**RE: Meridian Service Metropolitan District
Latigo Well Sites #2 & #3
COM – Comment Response Letter
COM-2333**

Below are responses to comments provided 06/07/23 – 06/09/23 for agency review of the above-referenced project. We have inserted our responses and actions taken in **blue** below each comment.

AGENCY: PCD Engineering Division, 06/07/23

AGENCY: PCD Project Manager, 06/09/23

MERIDIAN SERVICE METROPOLITAN DISTRICT
 LATIGO WELL SITE #2
 OVERALL SITE PLAN

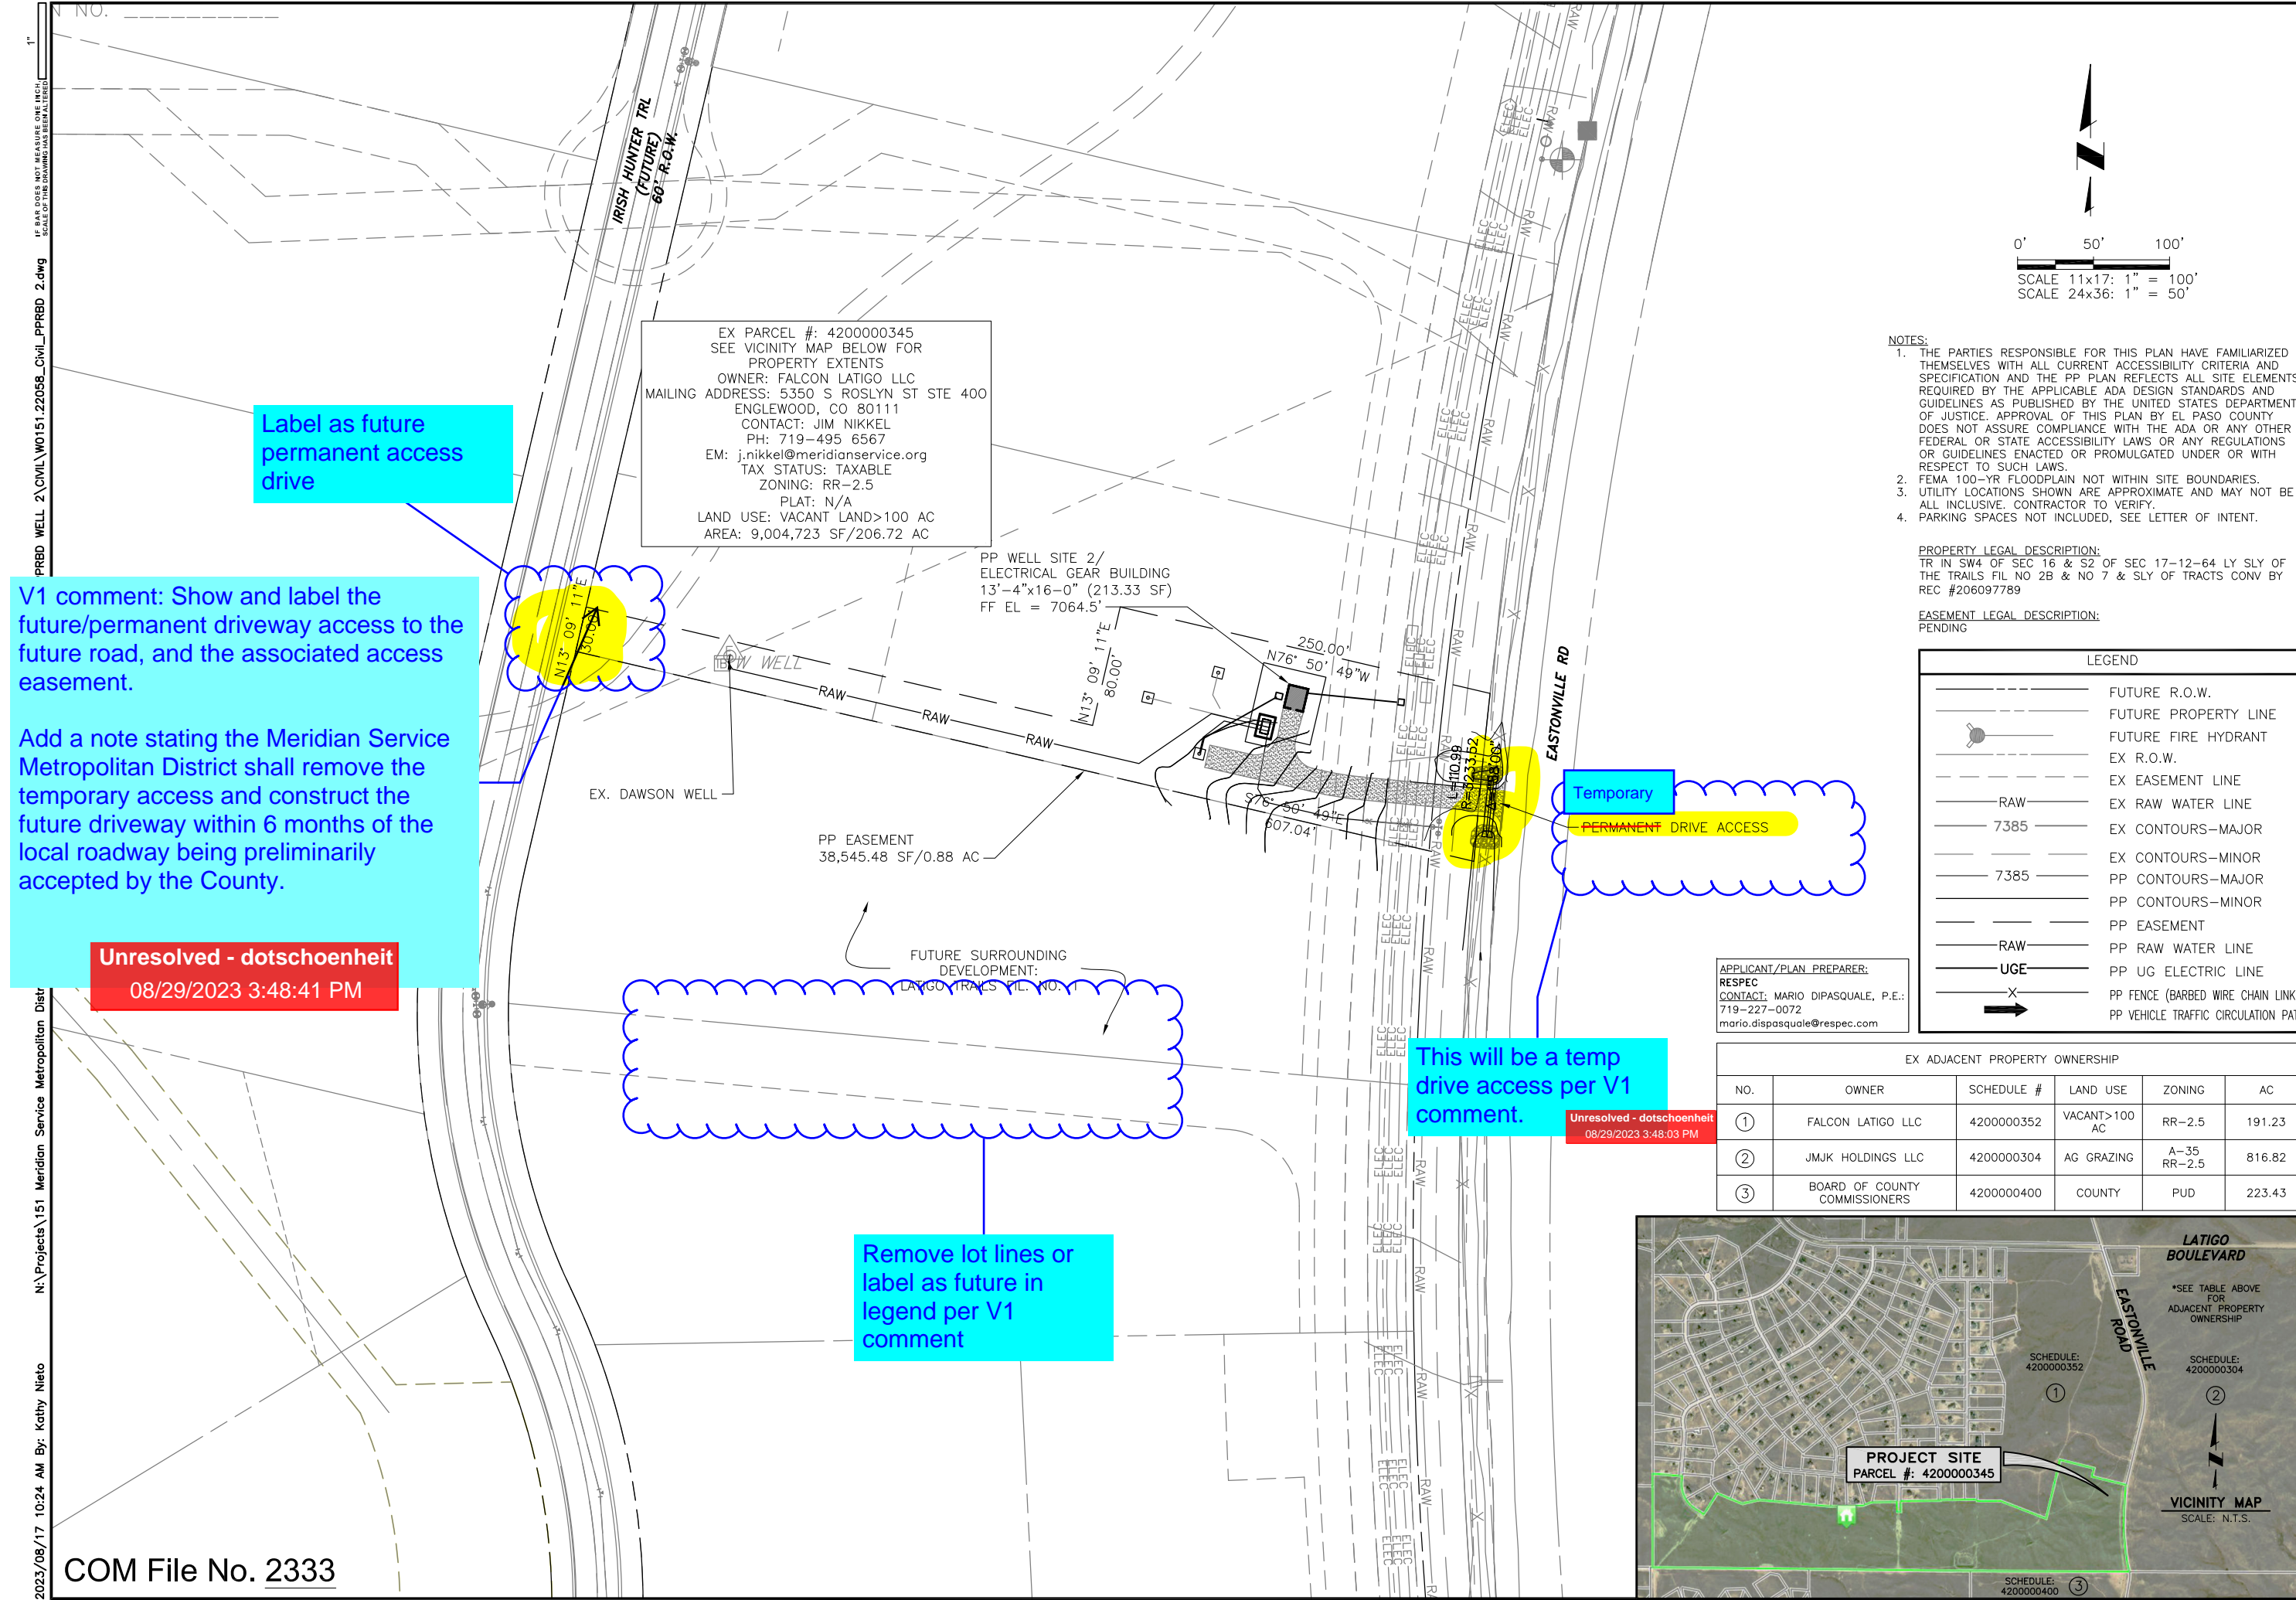
1. Site Plan Comments

1.1 Please provide owner/applicant contact information

1.2 Total building gross sq ft

1.3 Will there be parking at this site? If not, please specify

1.4 Label as temporary access

1.5 Remove lot lines or include in the legend as future.

1.6 Show and label the future/permanent driveway access to the future road, and the associated access easement.

Add a note stating the Meridian Service Metropolitan District shall removed the temporary access and construct the future driveway within 6 months of the local roadway being preliminarily accepted by the County.

1.7 Label as future road and ROW, provide dimensions of ROW

Both applicant and owner information has been added to Overall Site Plans and Site Development Plans.

Total building gross sq ft is shown on the plans, see Plan callouts.

No parking will be included at the sites, as originally stated (see previous Letter of Intent for specific request).

It is not our intent to have Well Site #2 access of Eastonville Road be temporary access. See response #1 above.

Future property line has been added to each Legend.

It is our intent that the access drive off Eastonville for Well Site #2 be permanent access due to the easement being located on a future single family residential lot. This will allow simpler access for large well pump equipment to access the well site. The well site is also located at the back of the lot.

Complete.
